Consultation Response from KC, Highways Development Management
2024/91612 Butternab Road, Beaumont Park, Huddersfield, HD4 7BA
Re-use of existing barn and new extension to form dwelling (within the curtilage of a listed building)
Date Responded: 24/09/2024. Responding Officer: D. Stainsby Responding Ref: K6-1NE/1

1 Proposed Ground Floor
 1 : 50

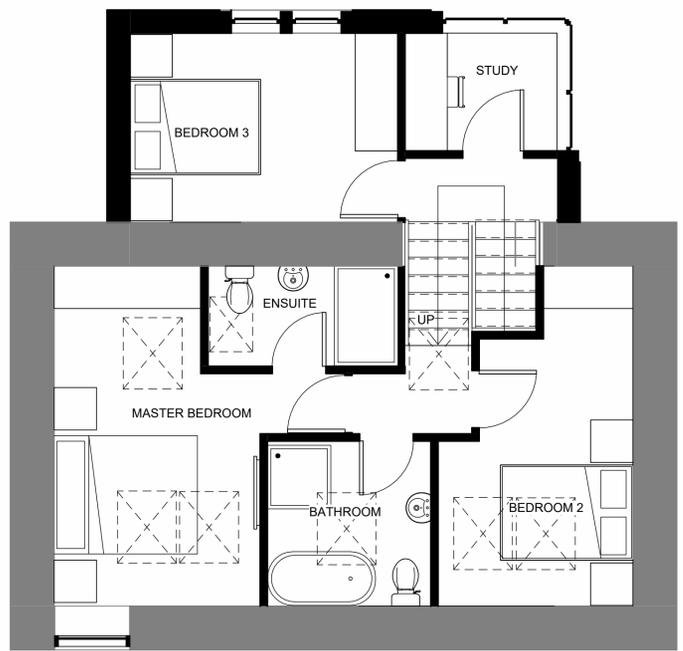
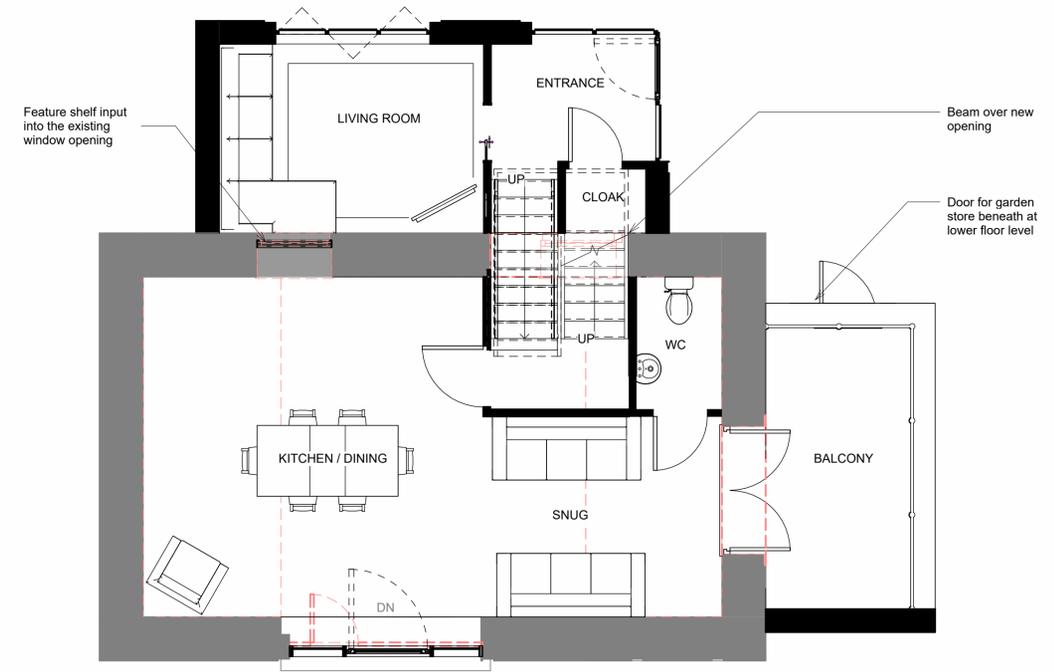
Two car parking spaces are proposed adjacent to the proposed dwelling and vehicles using these parking spaces can turn on the private drive to enable them to enter and exit Butternab Road in forward gear.

A bin storage area is shown on the plan. However, a bin collection/presentation point should be shown located adjacent to the public highway.

The bin collection/presentation point must not obstruct the adopted highway or the access road.
